Date: Dec 10, 2014
Project: 97 State Street, Portland, ME
From: David Tetreault
Subject: Response to Building Dept. Review Comments

Attached are calculations that I prepared for support of the exterior porch floor beam as shown on Structural Section 7/A2.01. Following are the design criteria used:

7 | STRUCTURAL SECTION
1" = 1'-0"

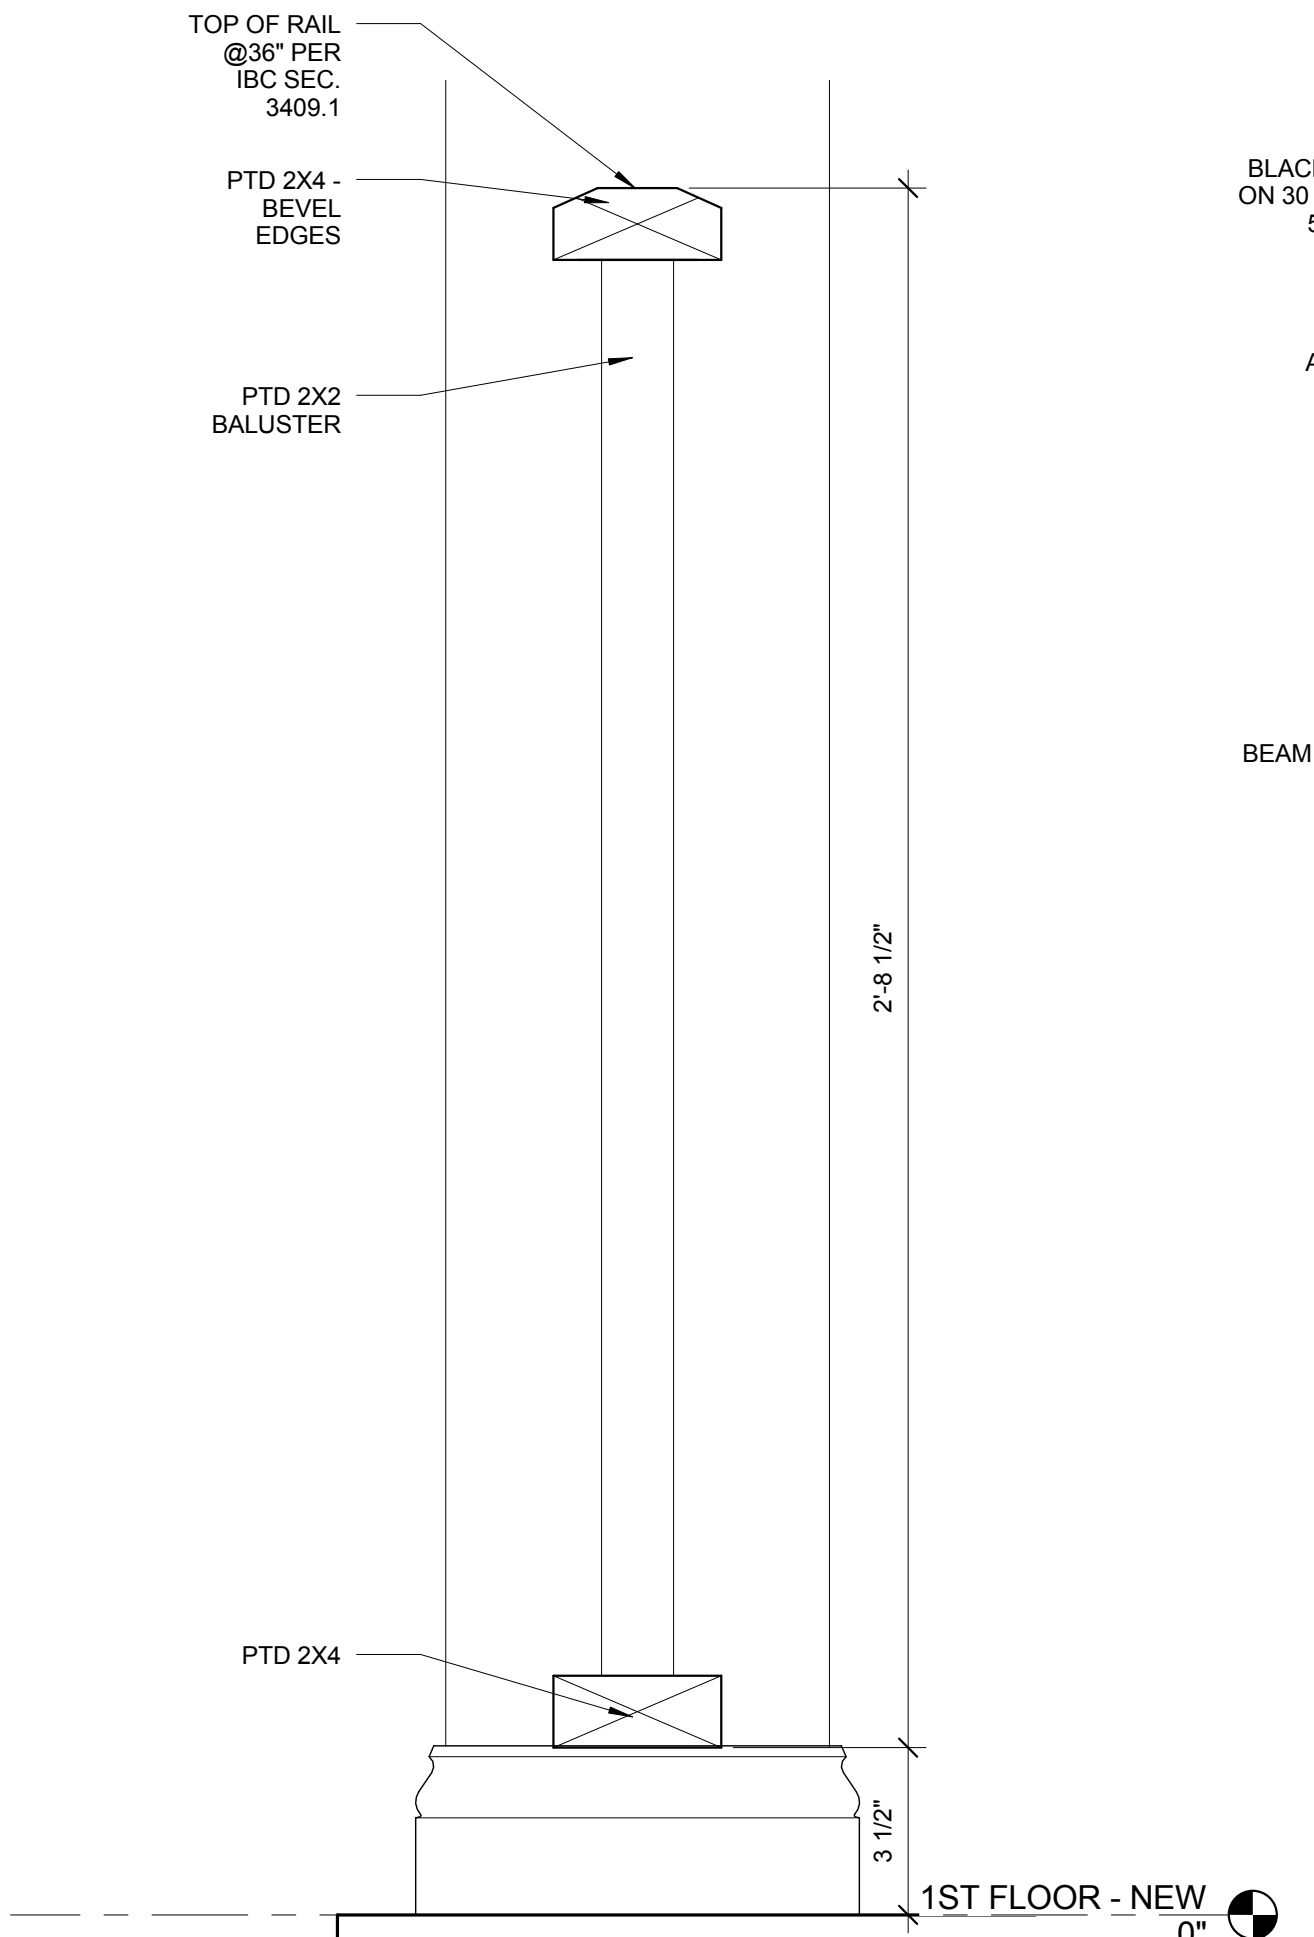
Floor Dead Load	12 PSF
Floor Live Load	100 PSF
Fastener Allowable Shear	940 Pounds
